Please ask for: Ms Iqraa Malik
Email: iqraa.malik@terraquest.co.uk
Telephone: 0121 234 1390
Our Ref: Y/134/21/HH
Your Ref:
Date: 21st October 2021

Application for Planning Permission for Works or Extension to a Dwelling

Development: Single storey, part two storey rear extension
Location: 3 Cherry Avenue Yapton BN18 0LB

PROPOSED FIRST FLOOR PLAN

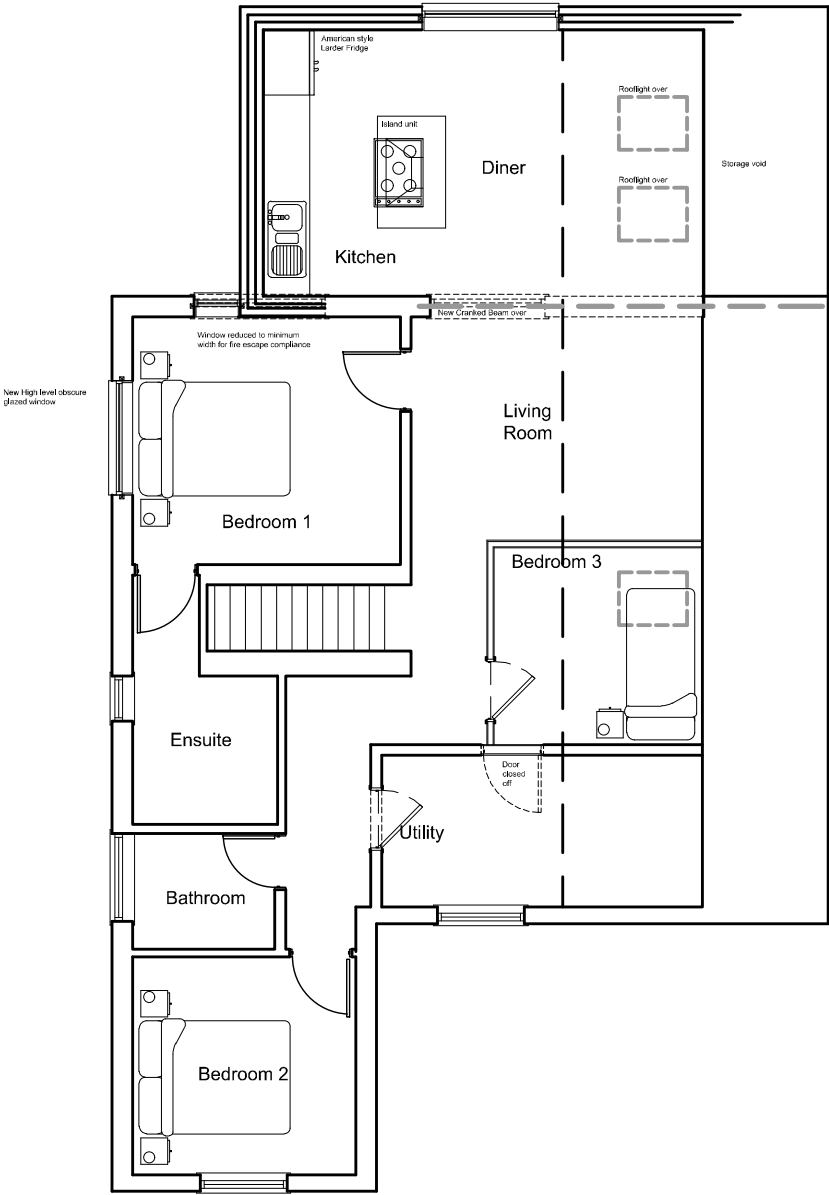
The new bedroom window on the proposed first floor plan is missing from the north east elevation. Please amend.

Drawing Proposed Alterations and Extension
Existing Plans

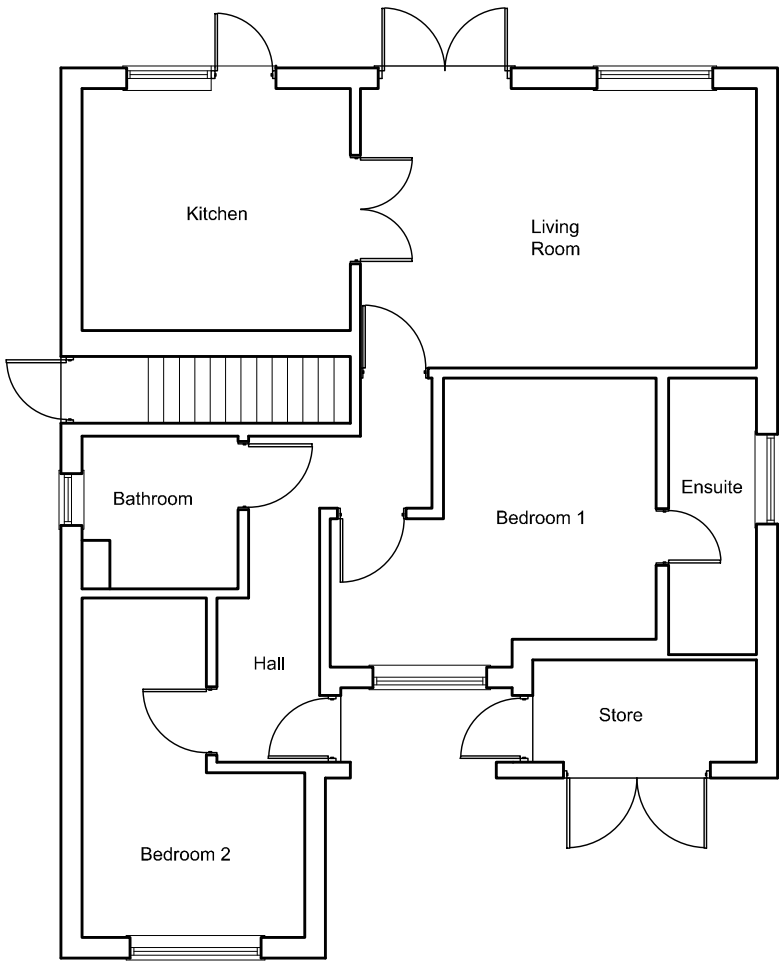
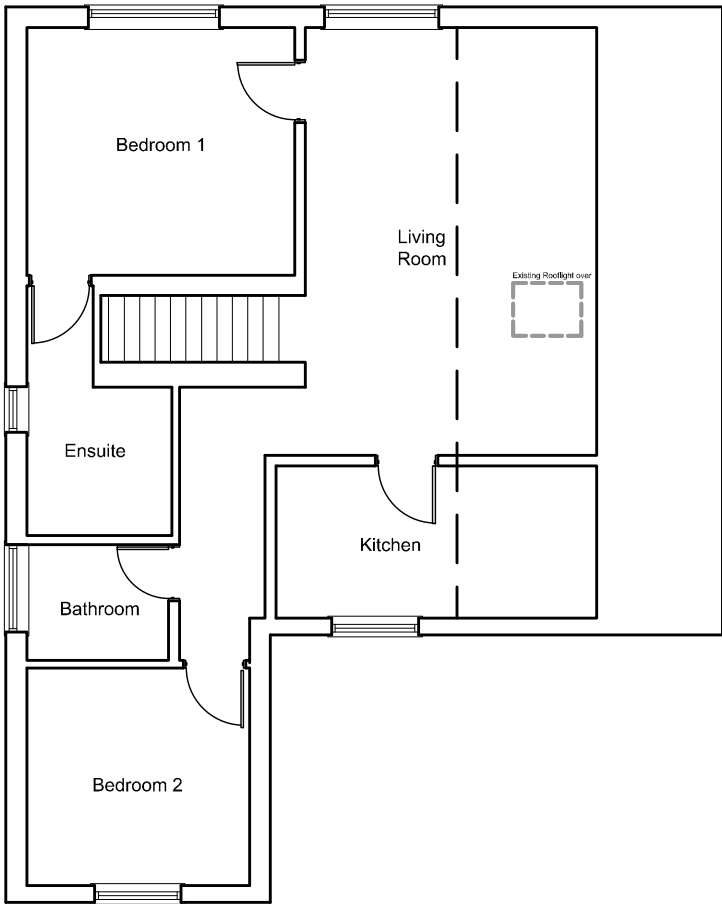
The existing ground and first floor plans are labelled wrong. Along with this, the existing rooflight is missing from the existing first floor plan. Please review and amend.
